Appendix 7
Stage 1 Road Safety Audit
Designer's Response

Stage 1 Road Safety Audit

Roundstone Lane, Angmering

Designer's Response to Stage 1 Road Safety Audit

Drawing 22067/104C Proposed Raised Junction

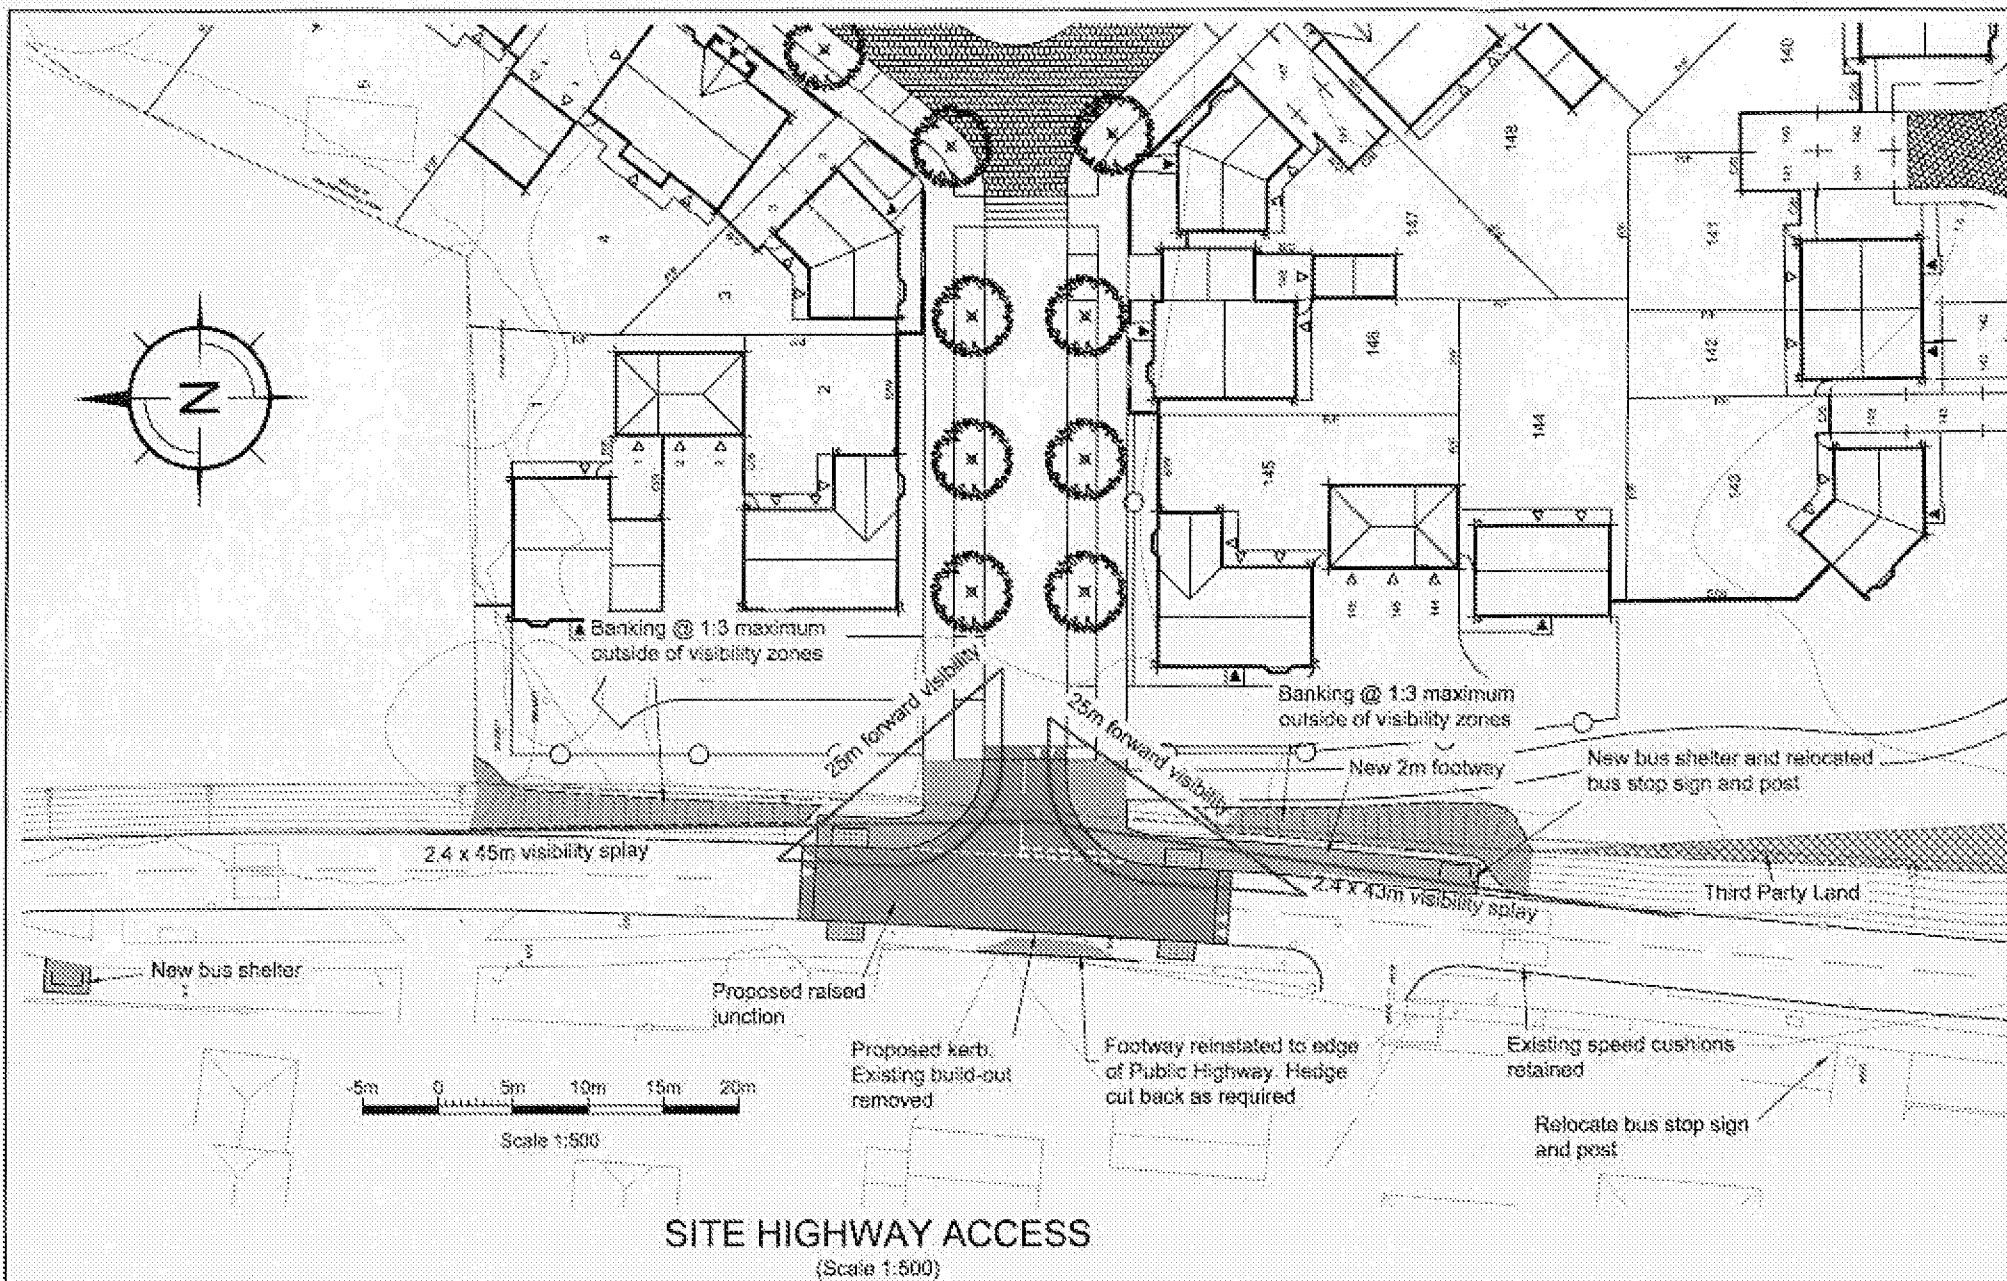
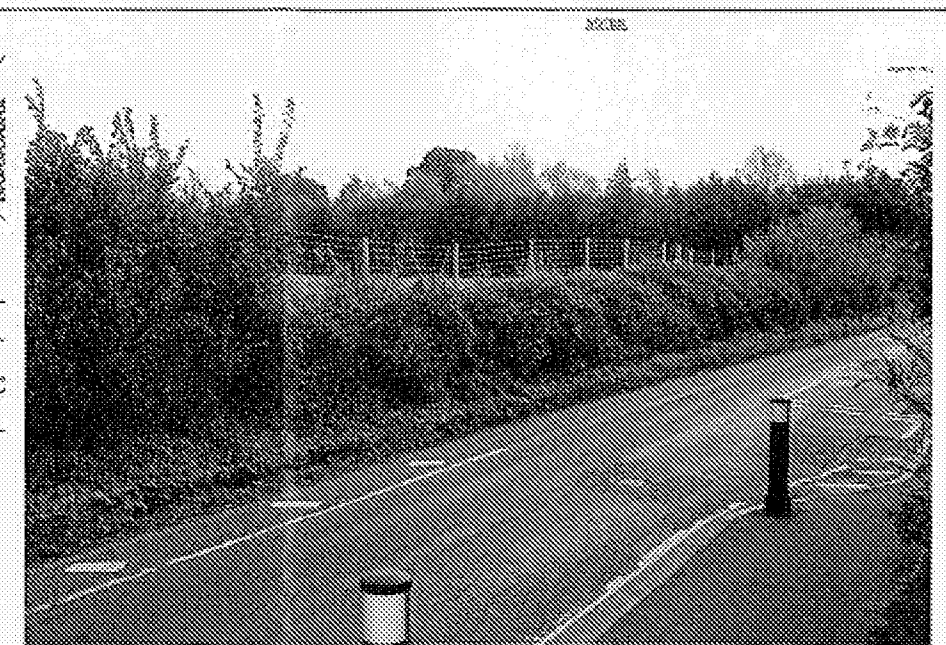
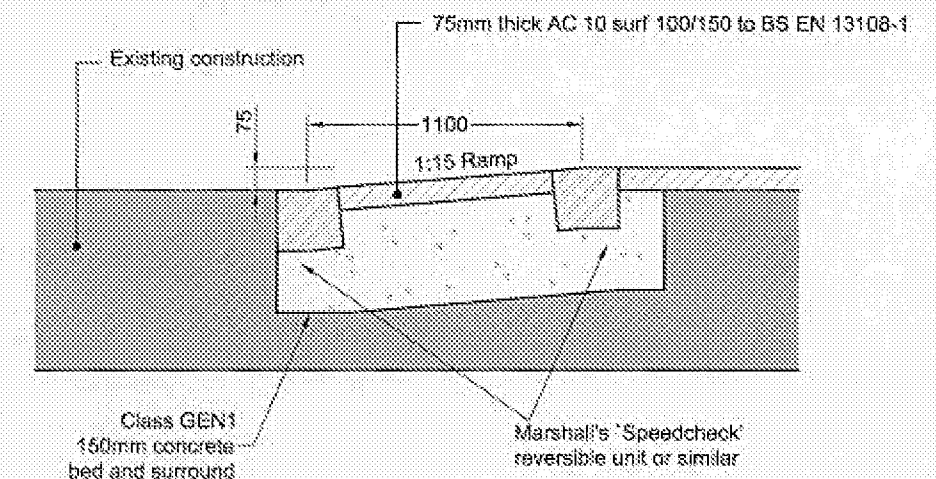
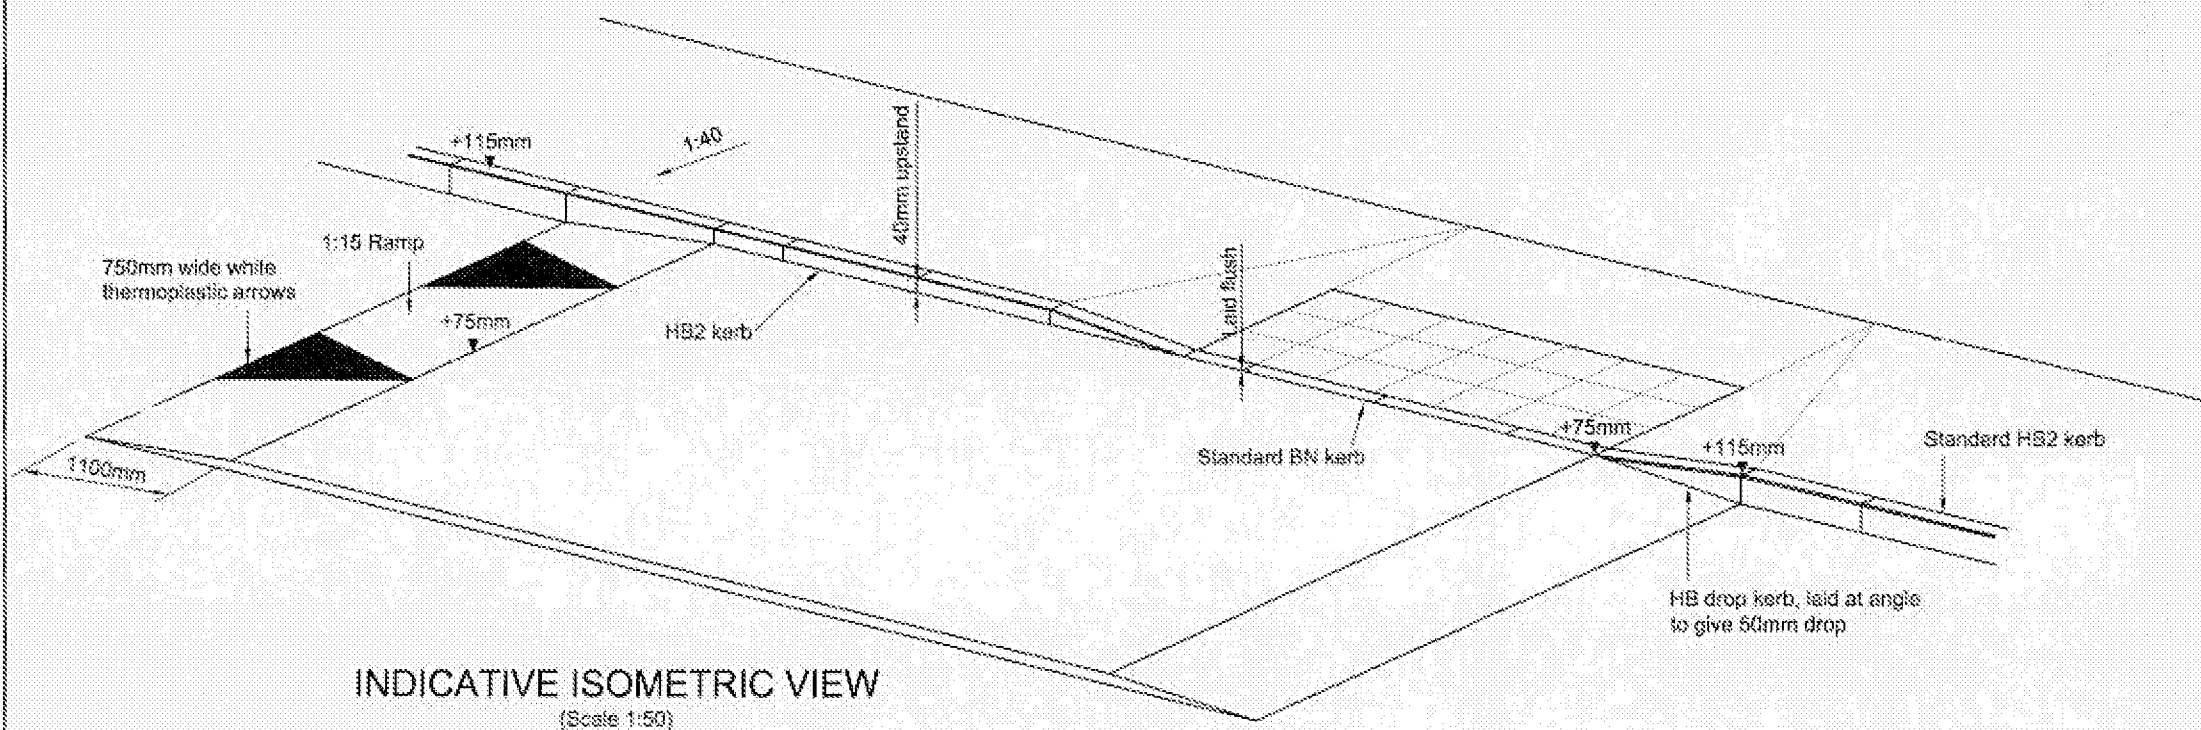
2.1.1 Location: New Access on Roundstone Lane – Location 3

Summary: Presence of build-out opposite proposed access could increase risk of the priority system being violated and potential collisions

The proposed access at Location 3 on Roundstone Lane will be directly opposite a build-out which forms part of a priority system. Once the access is constructed there is a risk that drivers will attempt to use the bell-mouth to pass each other and ignore the priority system. This could lead to vehicles conflicting with those approaching the junction on the new access road.

Remove the build-out.

Safety Audit Comment	Recommendation	Designer's Response
2 General		
2.1 Access		
2.1.1 Location: New Access on Roundstone Lane – Location 3		
Summary:		
Presence of build-out opposite proposed access could increase risk of the priority system being violated and potential collisions		
The proposed access at Location 3 on Roundstone Lane will be directly opposite a build-out which forms part of a priority system. Once the access is constructed there is a risk that drivers will attempt to use the bell-mouth to pass each other and ignore the priority system. This could lead to vehicles conflicting with those approaching the junction on the new access road.	Remove the build-out.	We propose to remove the build-out and construct a raised table in place to form the priority junction as shown on drawing 104A attached.
